Submission for Job: #7056 Remediation, Restoration and Adaptive Re-Use of Campbell's Stores
https://majorprojects.affinitylive.com/?action=view_job&id=7056

Remediation, Renewal and Adaptive Re-Use of Campbell's Stores, The Rocks. SSD 7056

**SSD 15_7056: Campbell's Stores, 7-27 Circular Quay West, The Rocks
Remediation, Restoration and Adaptive Re-Use of Campbell's Stores**

03 NORTH ELEVATION
SCALE: 1:200

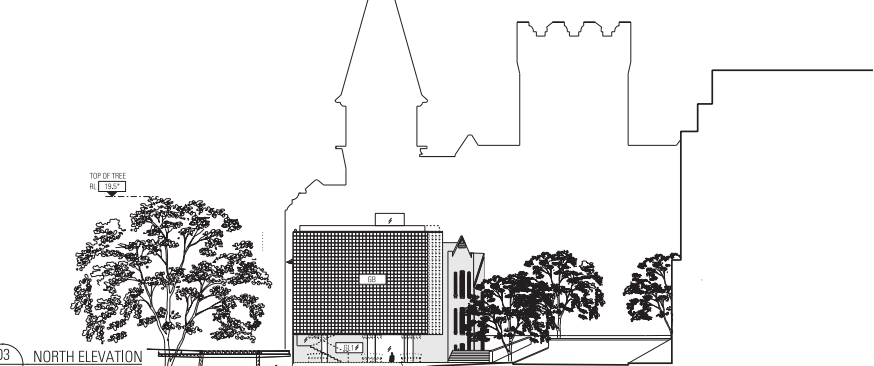
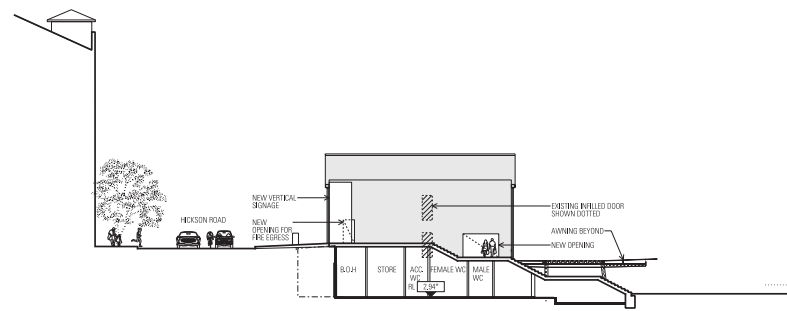
* The location is public owned land within the space designated as part of the Stores' heritage setting. We need to protect the heritage value of Campbell's Stores by not allowing a modern glass block building to intrude into the Stores' heritage setting and hide the northern side of the building.

- * The proposed building contravenes the 2014 Campbell's Stores Conservation Management Plan which the Heritage Council endorsed (esp. 7.5.5). The plan clearly outlines the area that needs to be retained around Campbell's Stores. This includes the area now proposed for this completely unsympathetic glass building. Approving it would destroy Campbell's Stores historic setting.

However, the National Trust questions whether a new building proposed to be added as Bay 12 at the northern end of the Campbell's Stores building is sympathetic in terms of architecture-in-context for this significant site within the Buffer Zone for the Sydney Opera House World Heritage Listing.
